From: Paul Cann
Sent: 25 January 2013 15:51
To: Planningecons
Subject: RE: Planning Consultation on: BE/181/12/

Engineers comments on surface water drainage:

Site Address: B & Q Plc, Arun Retail Park Shripney Road Bognor Regis
PO22 9NF

Description of Works: Erection of weather protection canopy with existing garden centre

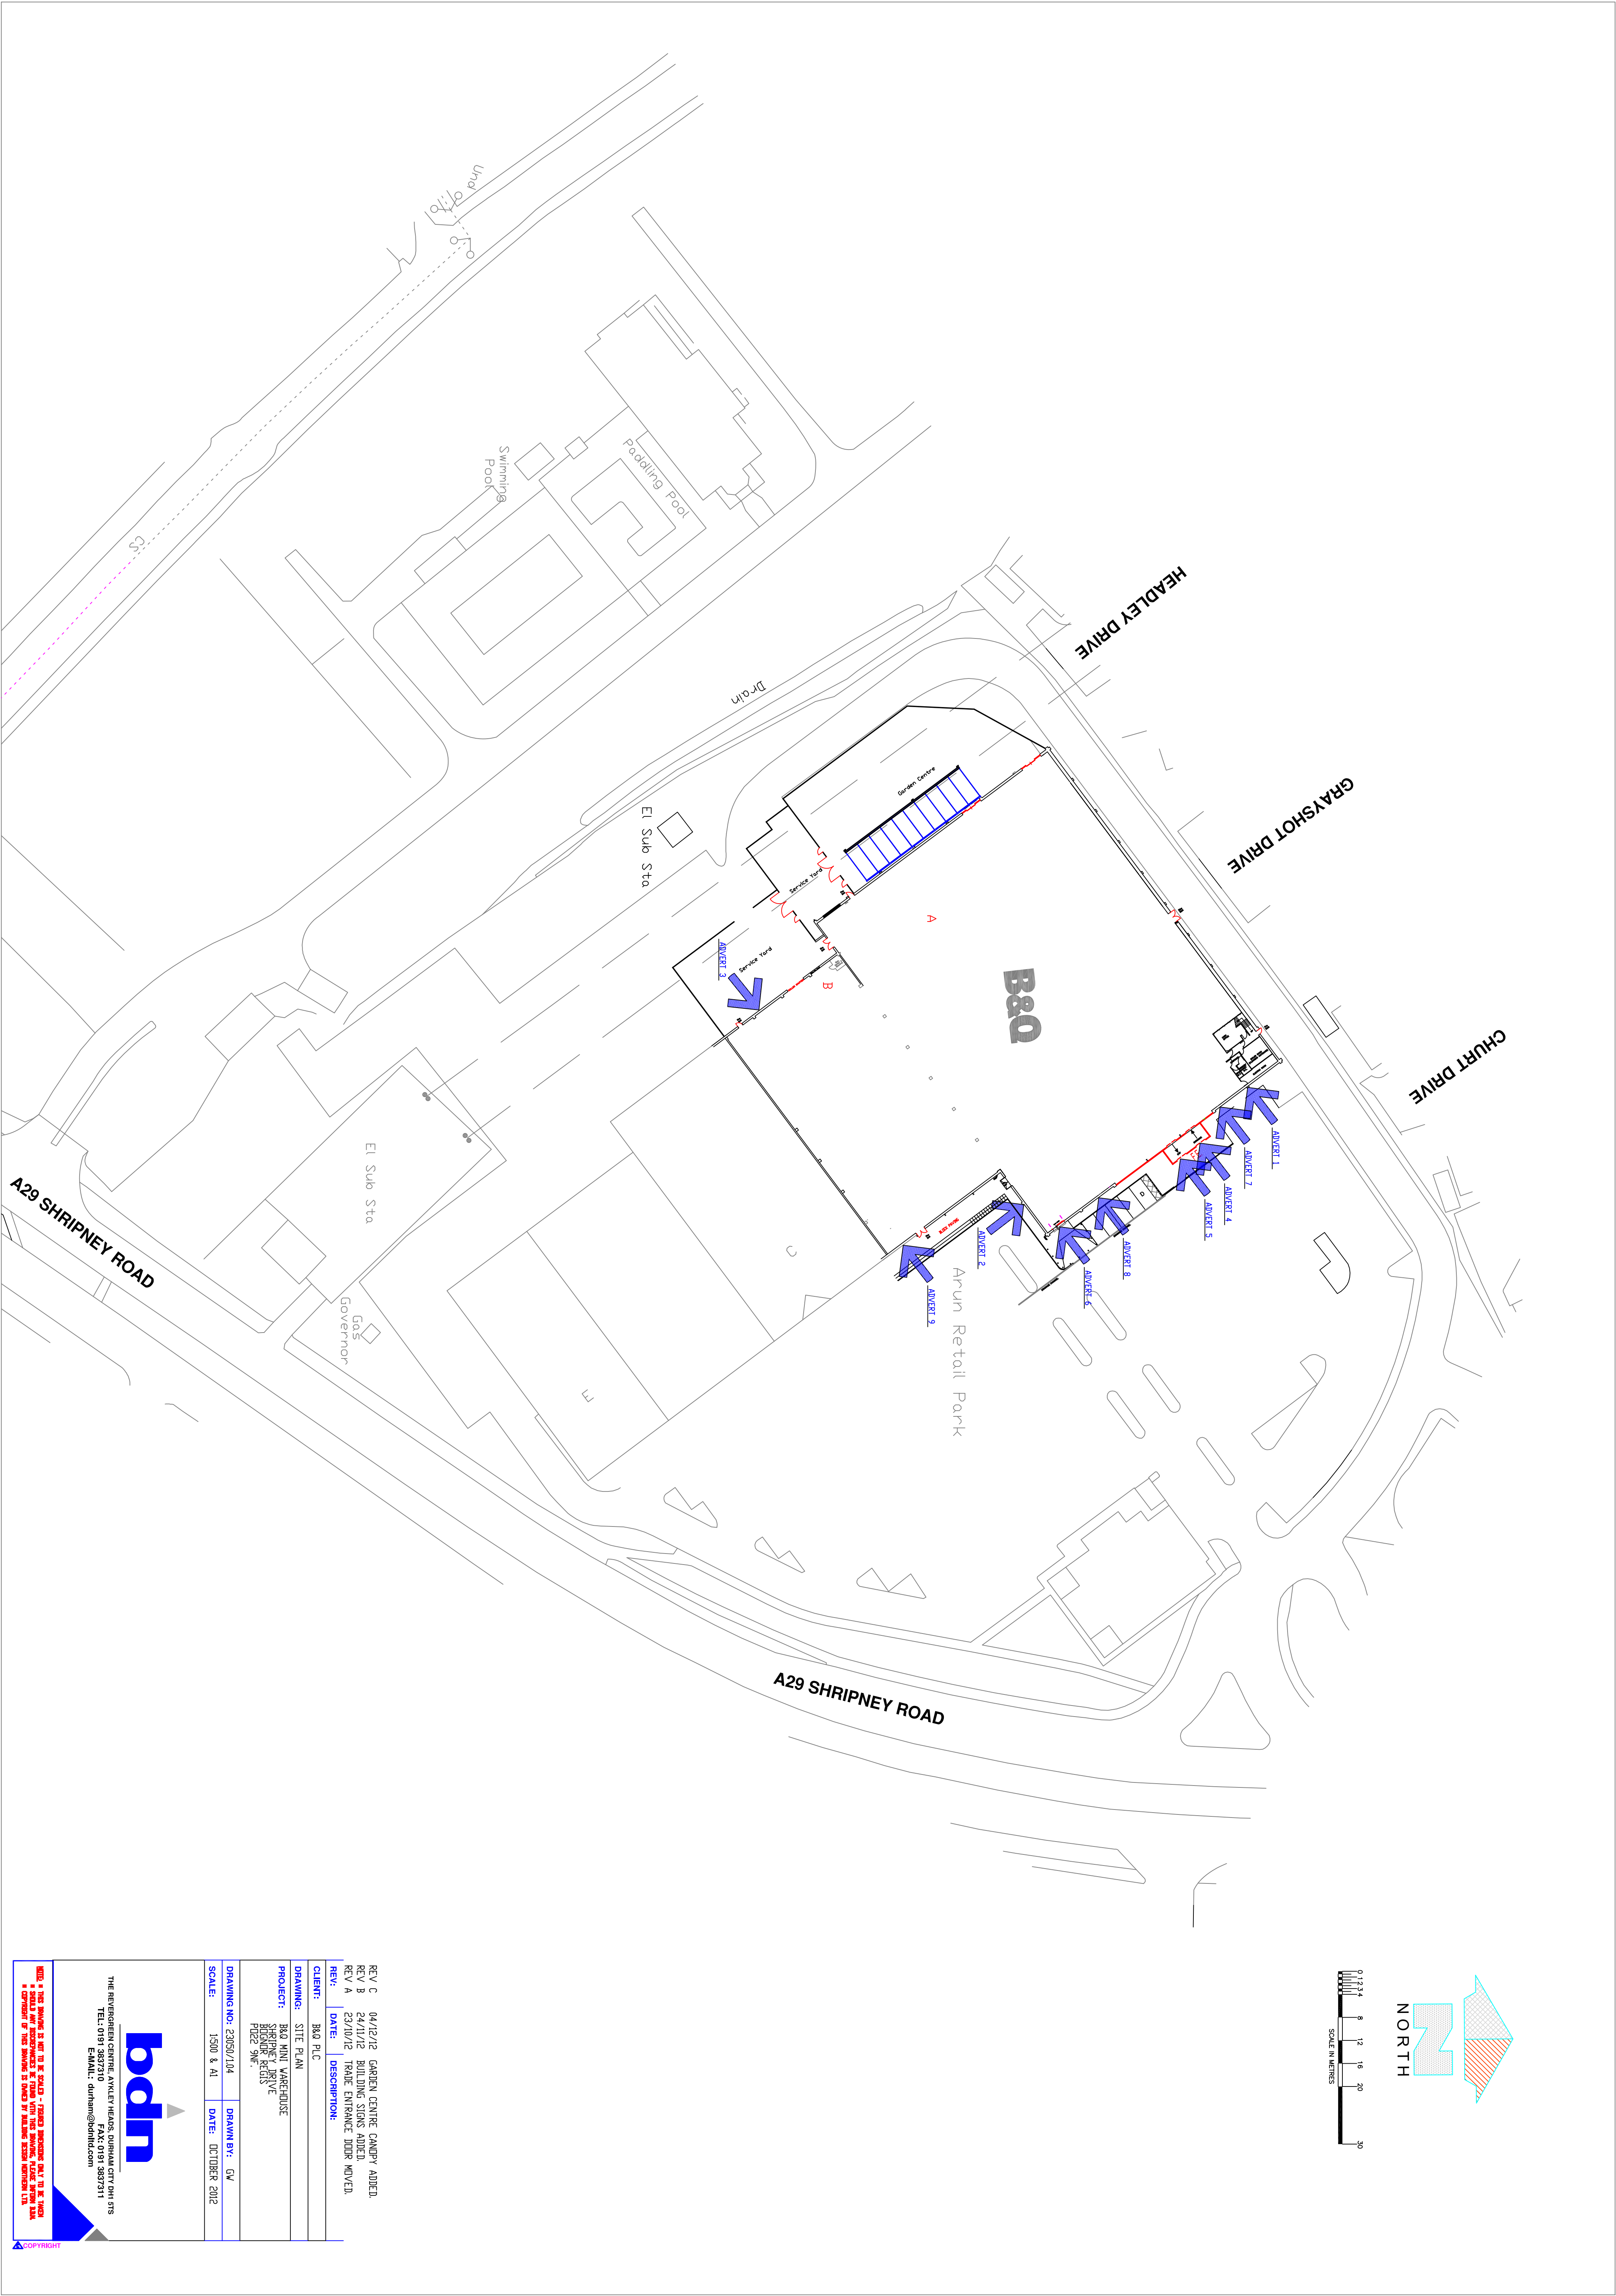
The applicant states on the application form that surface water will be discharged to 'main sewer'. No surface water to be discharged to the foul drainage system.

The applicant also states that the canopy will be sited over an area of existing concrete hard-standing. Runoff from the canopy will shed via a gutter and rainwater pipe system discharging onto the existing concrete hard-standing. This ultimately flows into the existing drainage channel which previously drained rainwater from the concrete area where the canopy is to be sited.

The applicant should verify that the existing drainage channel connects to a surface water drainage system and not into the foul drainage system.
